Waterbury Filing Nos. 1 and 2 Traffic Impact Analysis (LSC #204220) February 12, 2021

Engineering Review

LSC Response to TIS Redlines June 2021

Figure 9  
**Assignment  
 of Short-Term Site-Generated Traffic**  
 Waterbury Filing Nos 1 and 2 (LSC #204220)

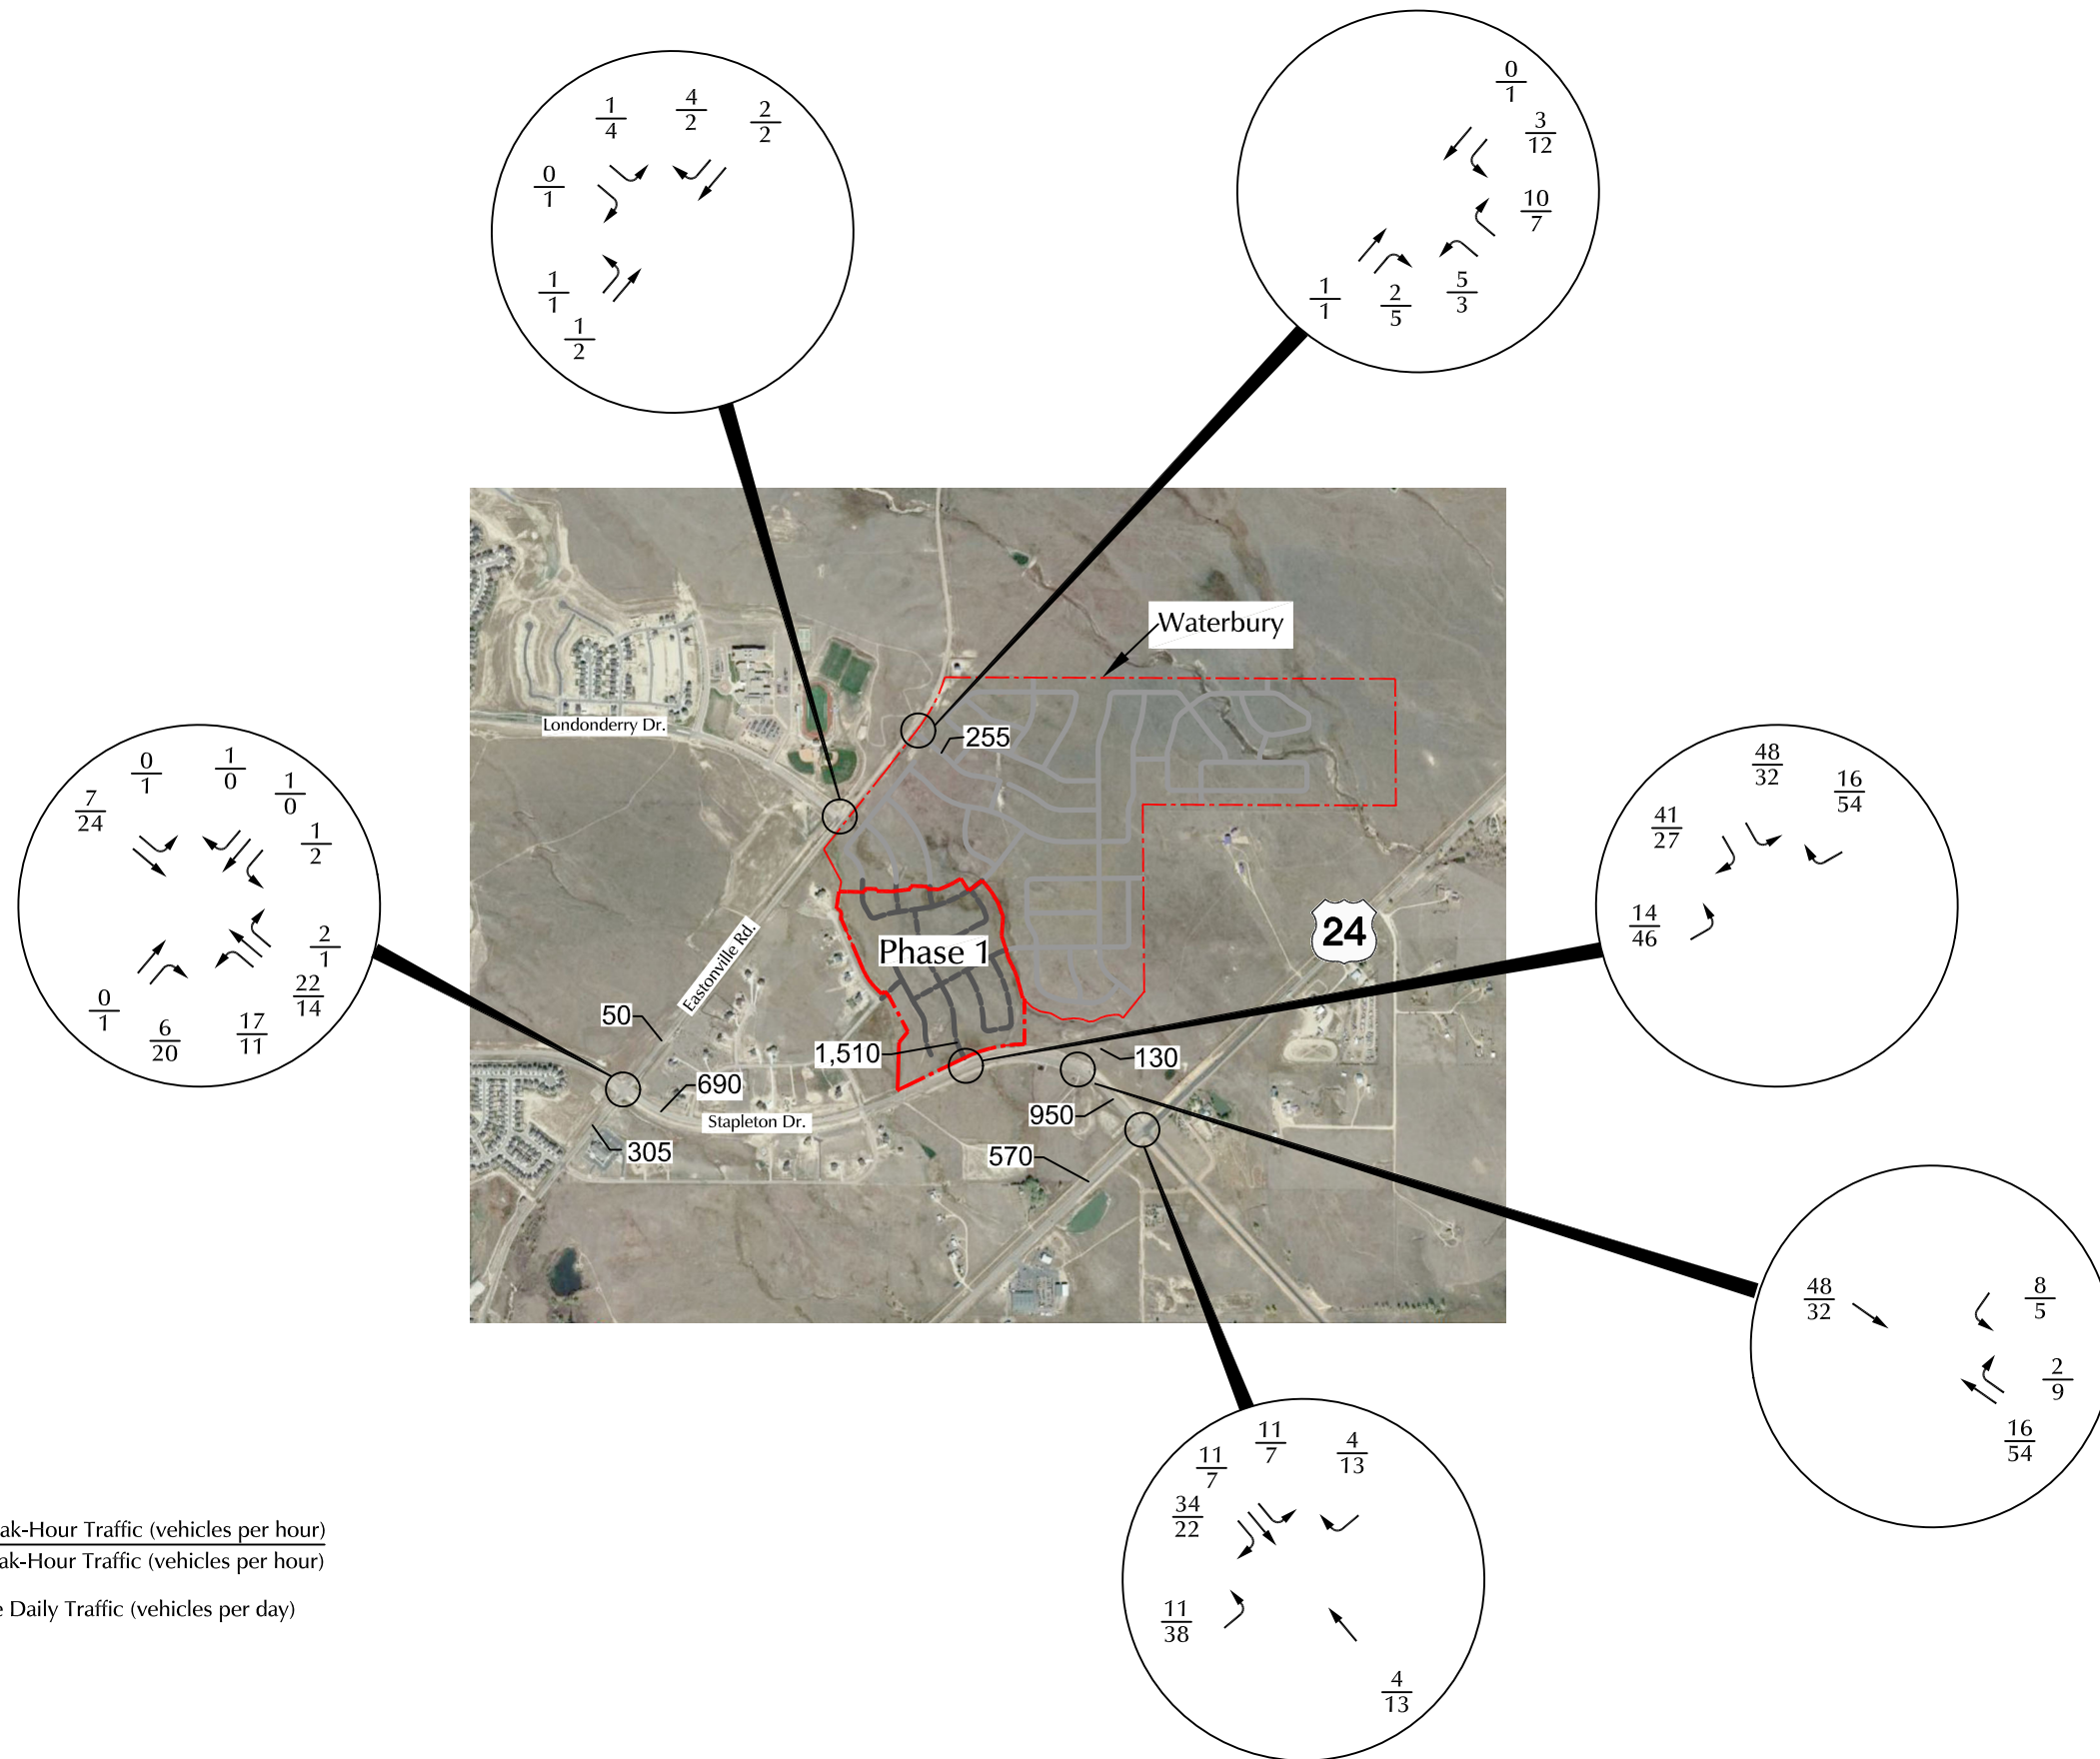
Number: 1 Author: dsdrice Subject: Callout Date: 6/14/2021 10:35:45 AM

[Provide Link ADT here](#)

Author: kdferrin Subject: Sticky Note Date: 9/28/2021 3:58:10 PM
LSC Response: The additional information has been added as requested.

Figure 10
Assignment
of Long-Term Site-Generated Traffic
 Waterbury Filing Nos 1 and 2 (LSC #204220)

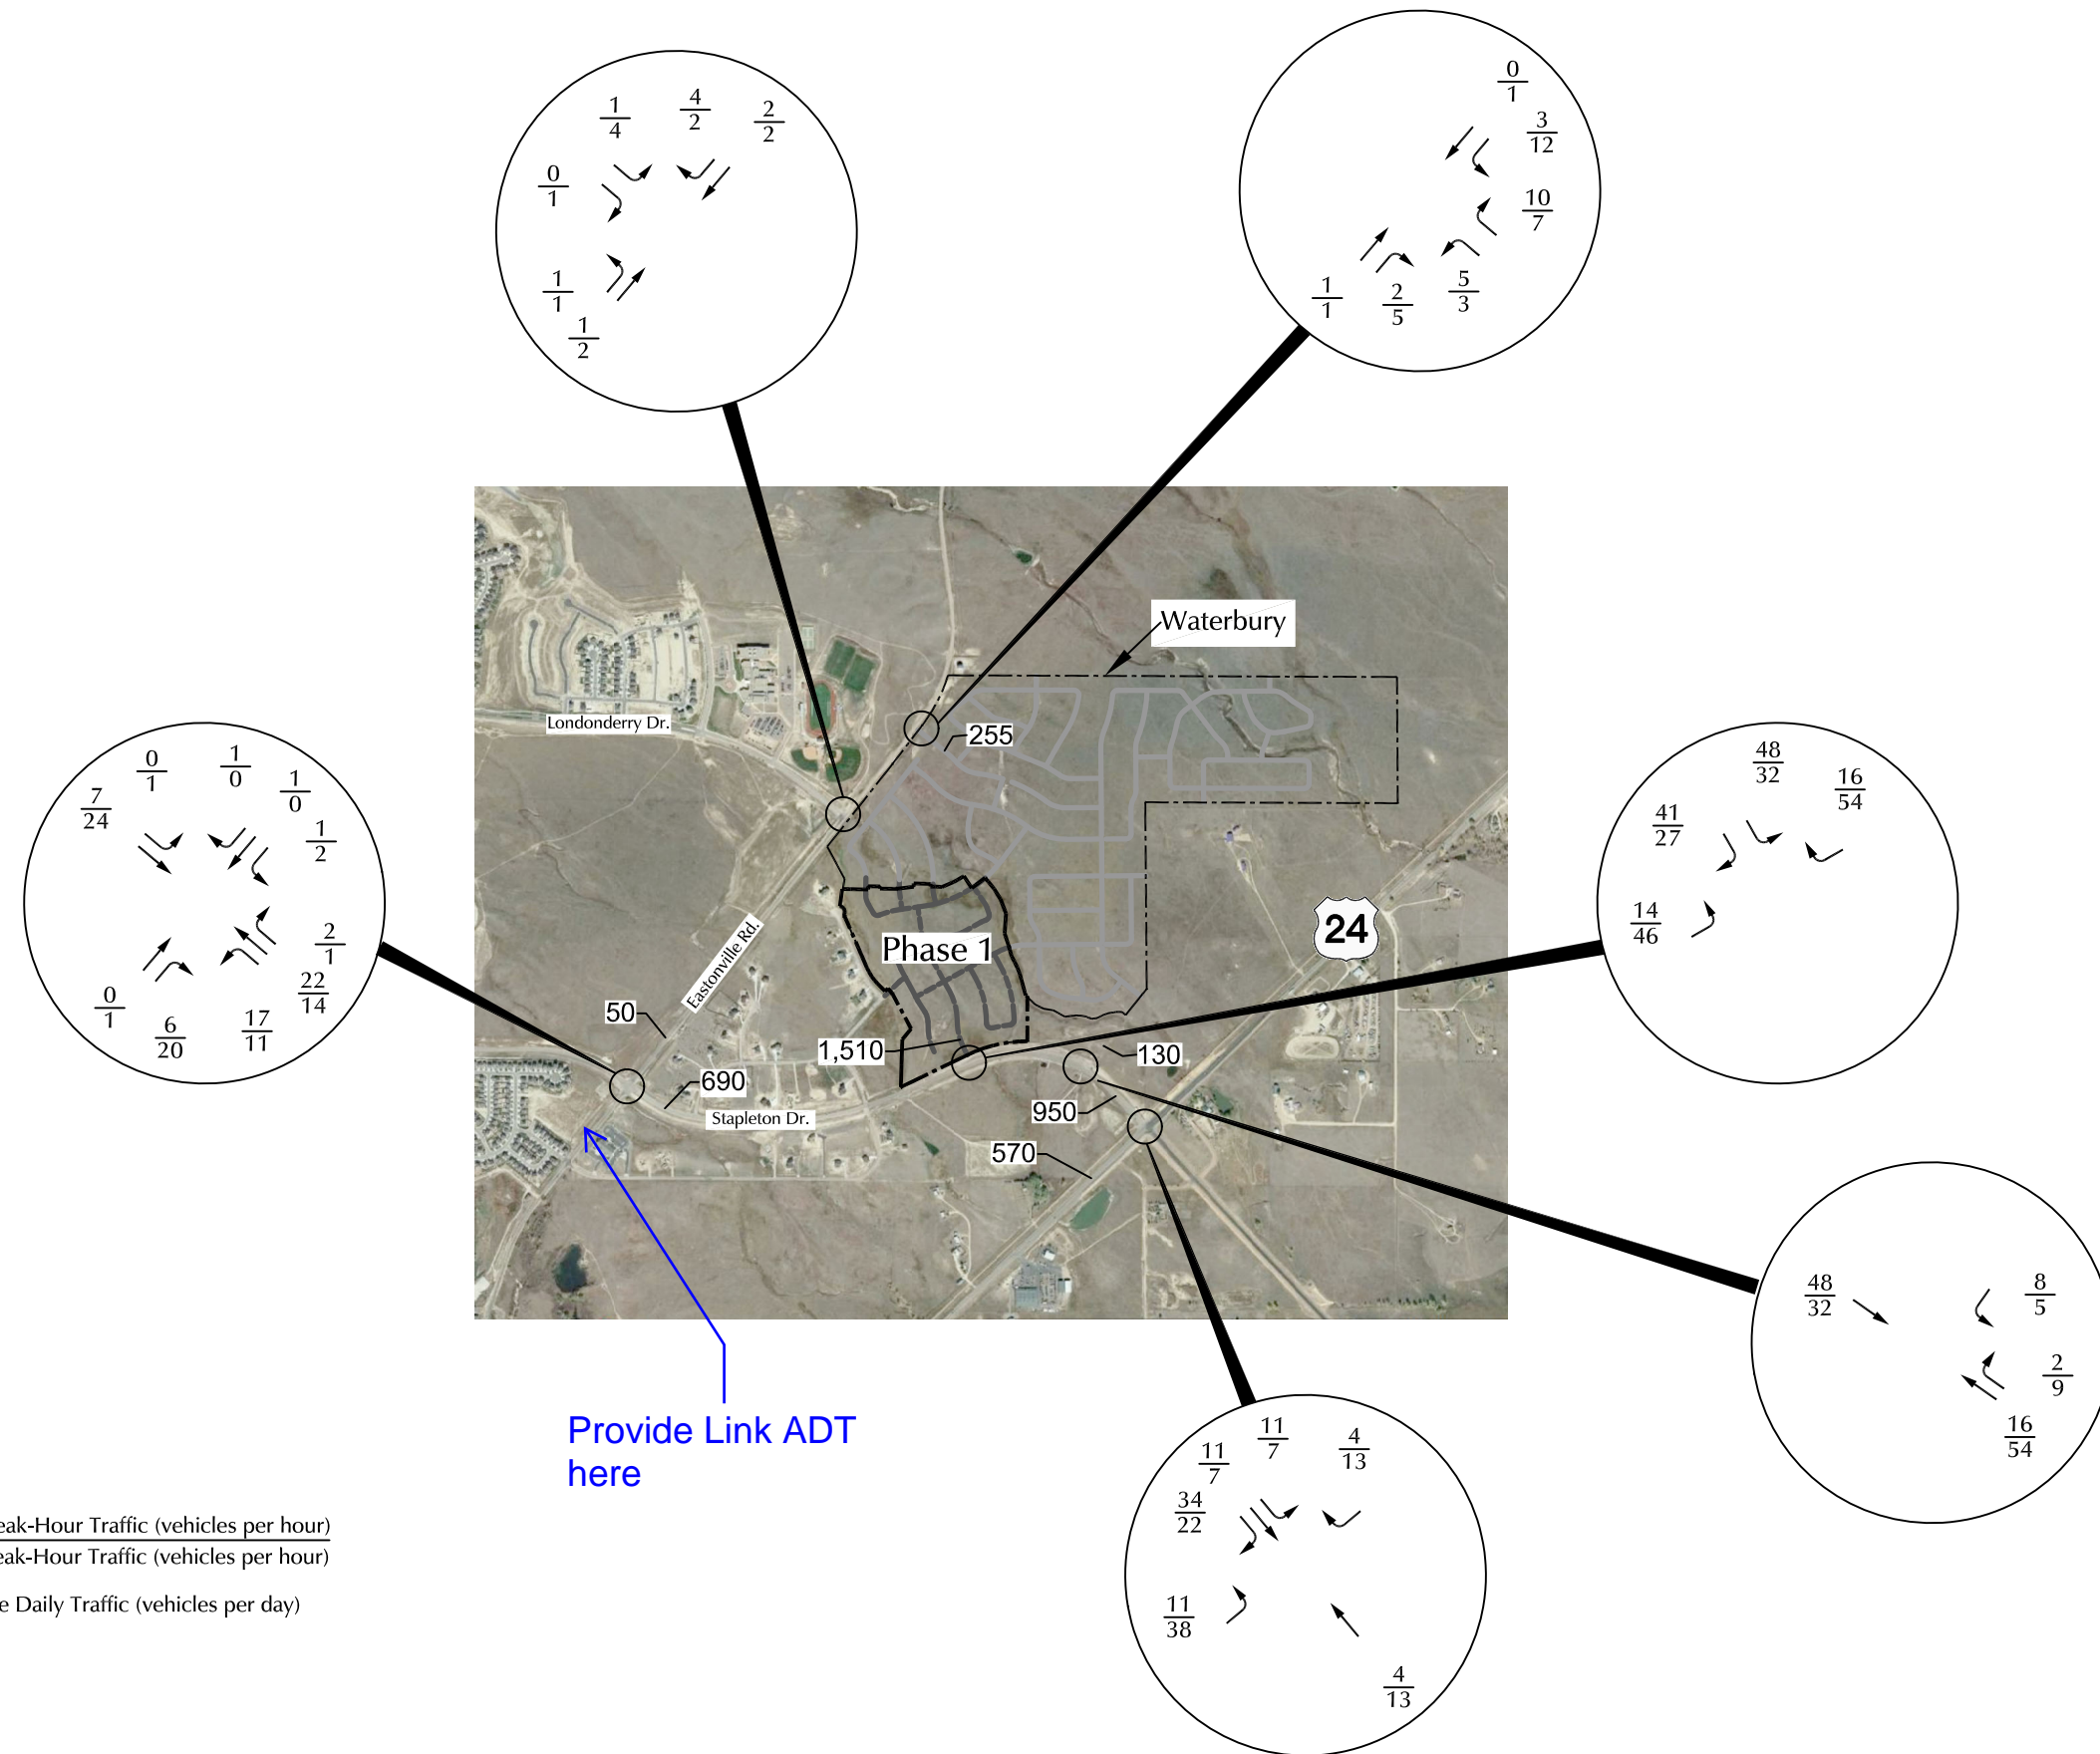
Number: 1 Author: dsdrice Subject: Callout Date: 6/14/2021 10:35:51 AM

[Provide Link ADT here](#)

Author: kdferrin Subject: Sticky Note Date: 9/28/2021 3:58:13 PM
LSC Response: The additional information has been added as requested.

Provide Link ADT
here

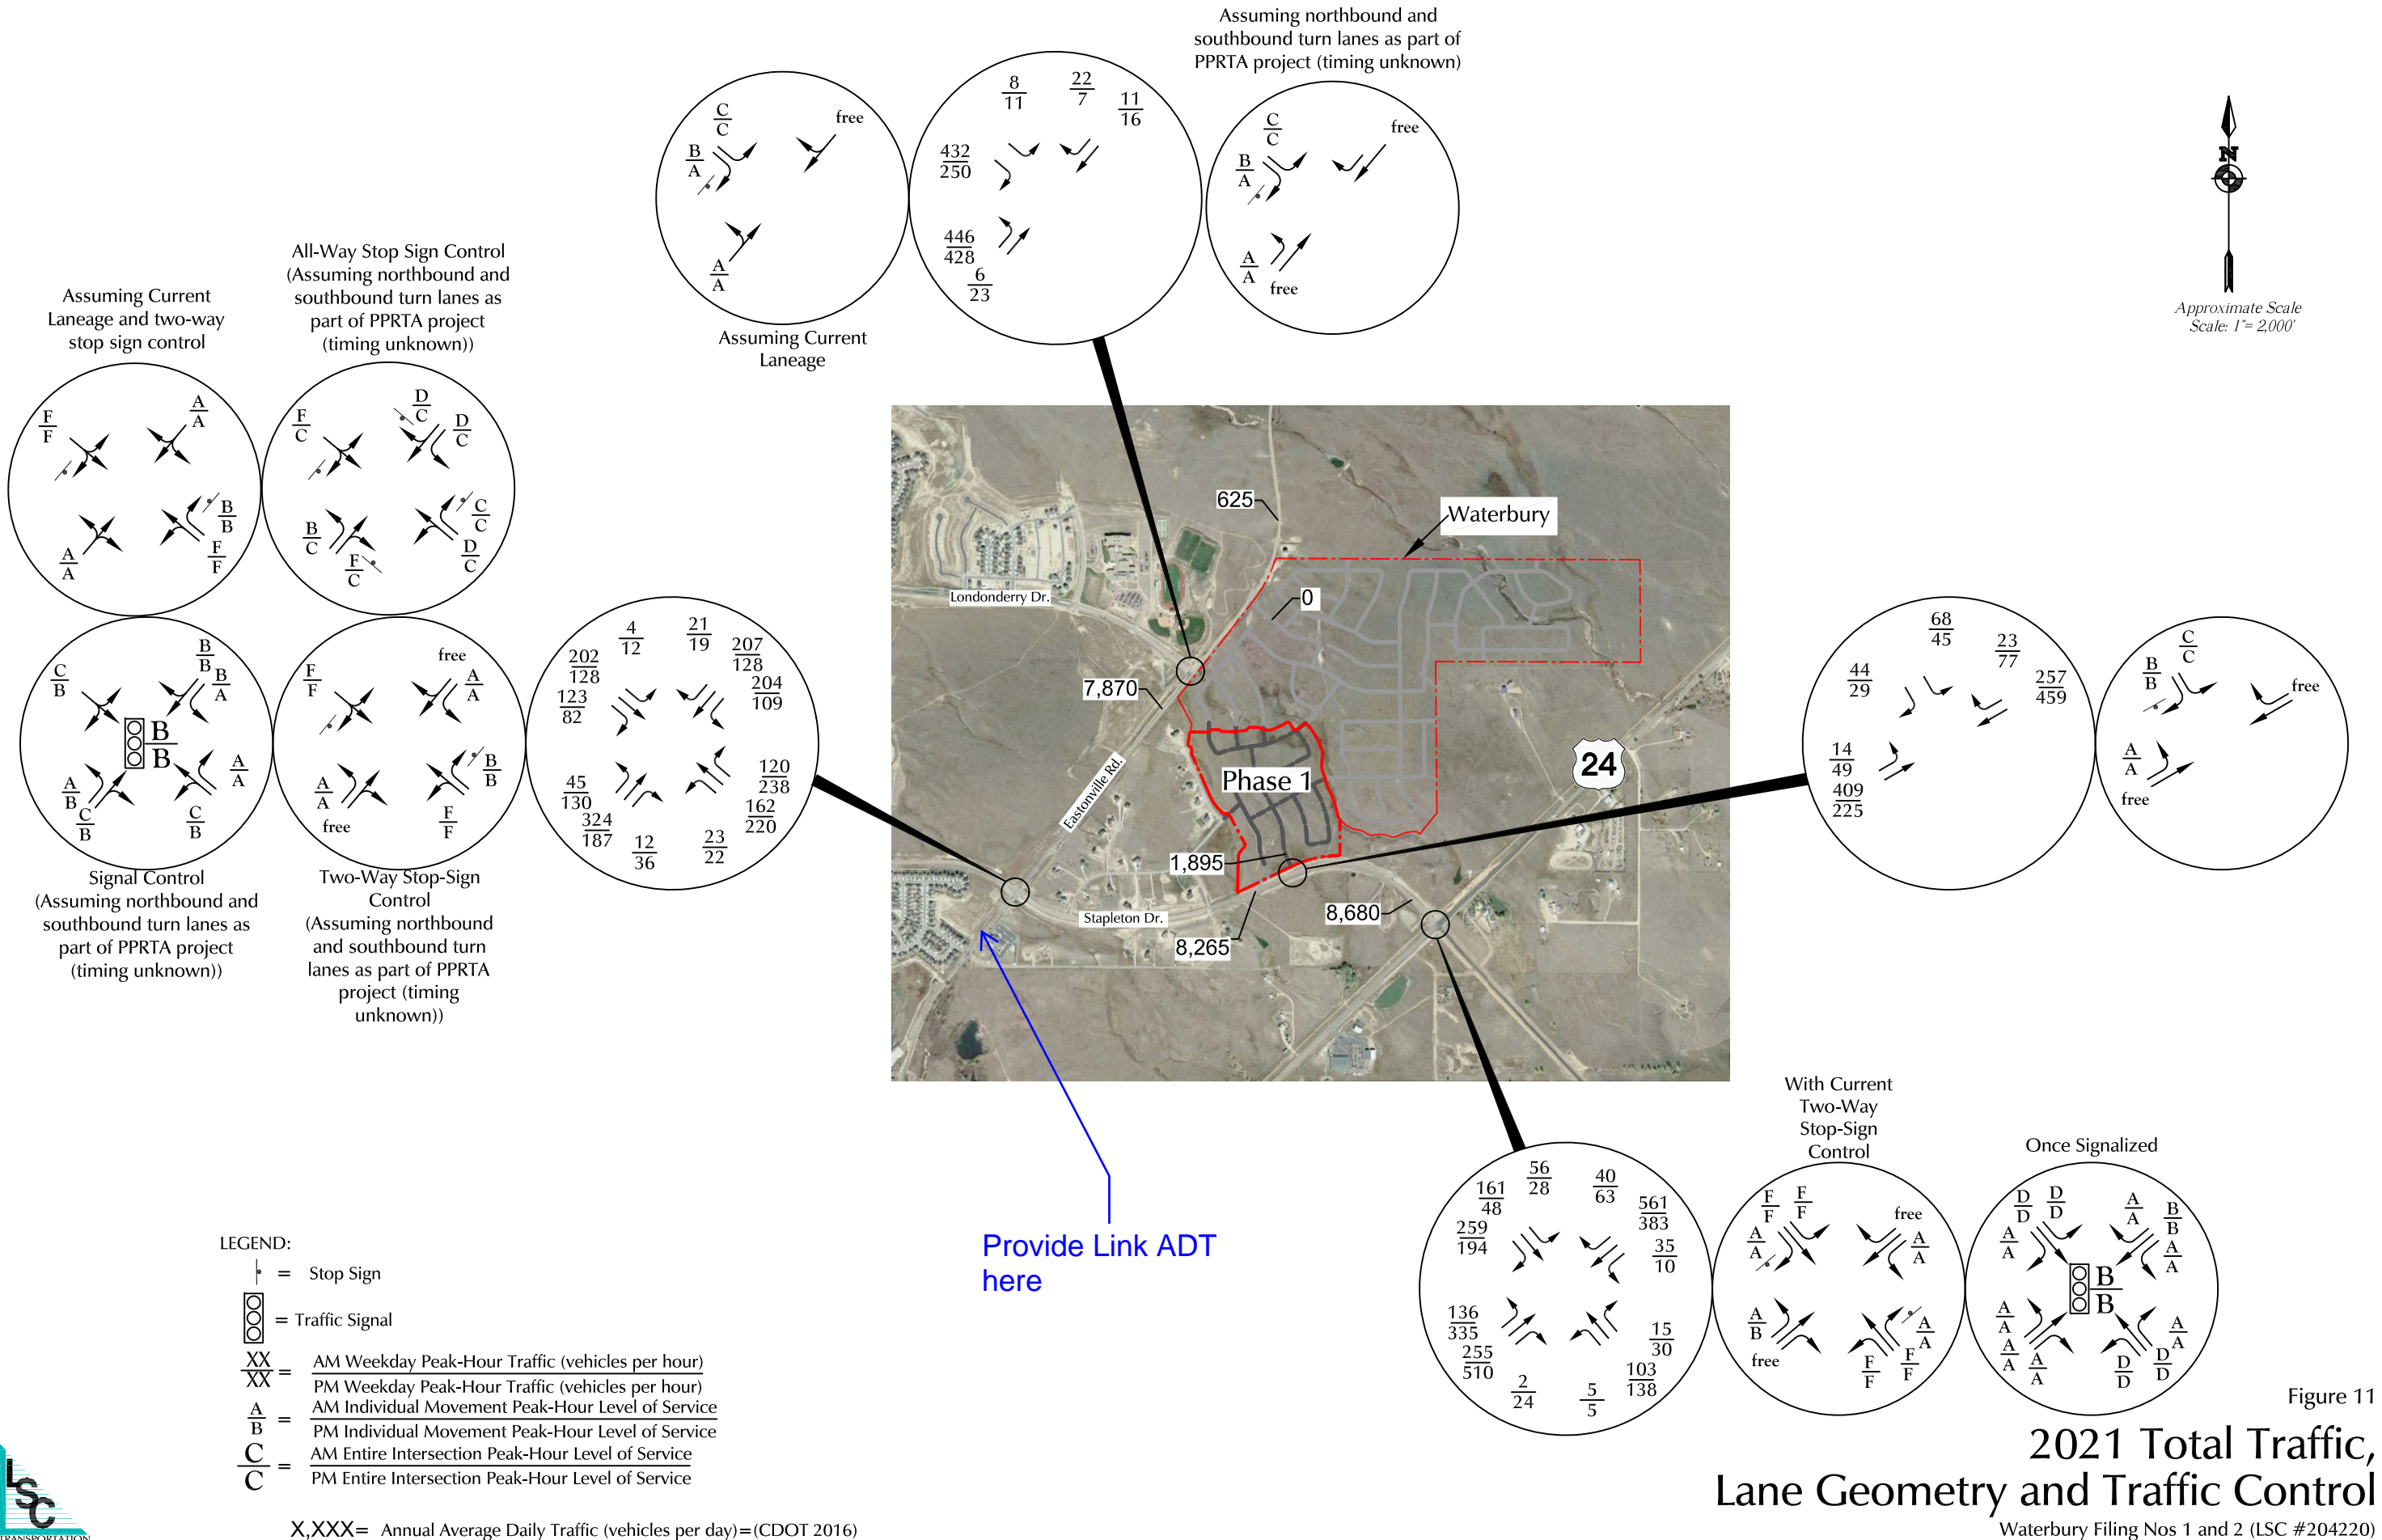
Number: 1 Author: dsdrice Subject: Callout Date: 6/14/2021 10:35:24 AM

[Provide Link ADT here](#)

Author: kdferrin Subject: Sticky Note Date: 9/28/2021 3:58:07 PM
LSC Response: The additional information has been added as requested.
